December 2, 2024

RE: Administrative Determination (Prophet Elijah Antiochian Orthodox Church) – Stream Setbacks

Request for minor modification to stream buffer in City of Ellensburg UGA.

Site Plan for CU -24-000008

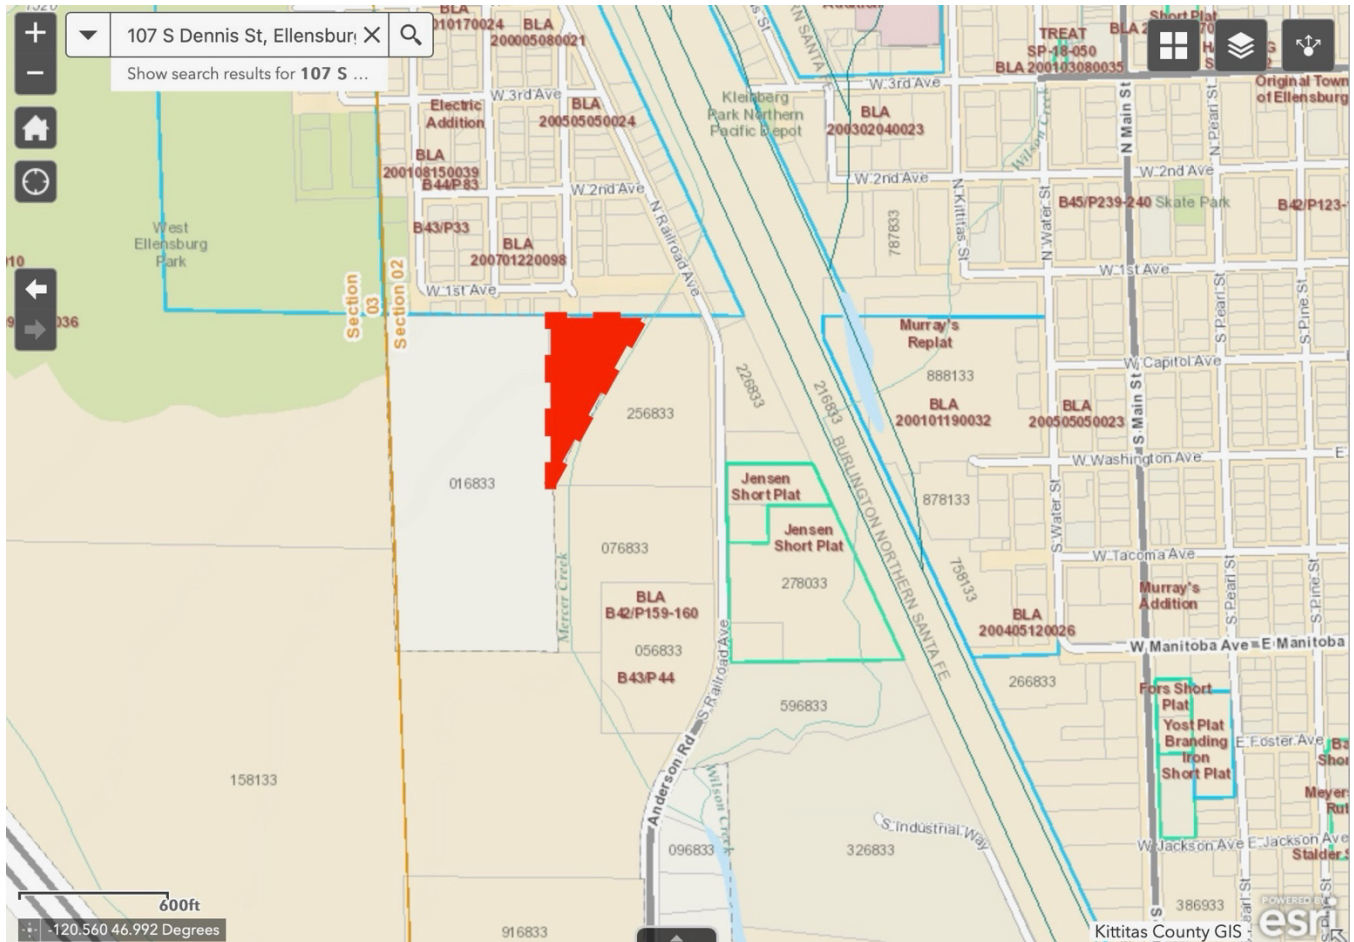
Kittitas County Community Development Services has reviewed the proposed site plan for the addition and parking lot for the church. Upon conducting a site visit on parcel 026833 it was determined that the stream buffer for Mercer Creek which flows on the eastern boundary of the property should be 85 feet per the City's critical areas ordinance. It was determined that there is an interrupted buffer on the edge of the planted lawn that would permit you to build the parking lot and church wing addition maintaining a 75-foot buffer. In exchange for allowing the 75-foot buffer we will require some mitigation of additional plantings along the stream on either side of the buffer encroachment by following the replacement ratio provided in Table 17A.07.070.6
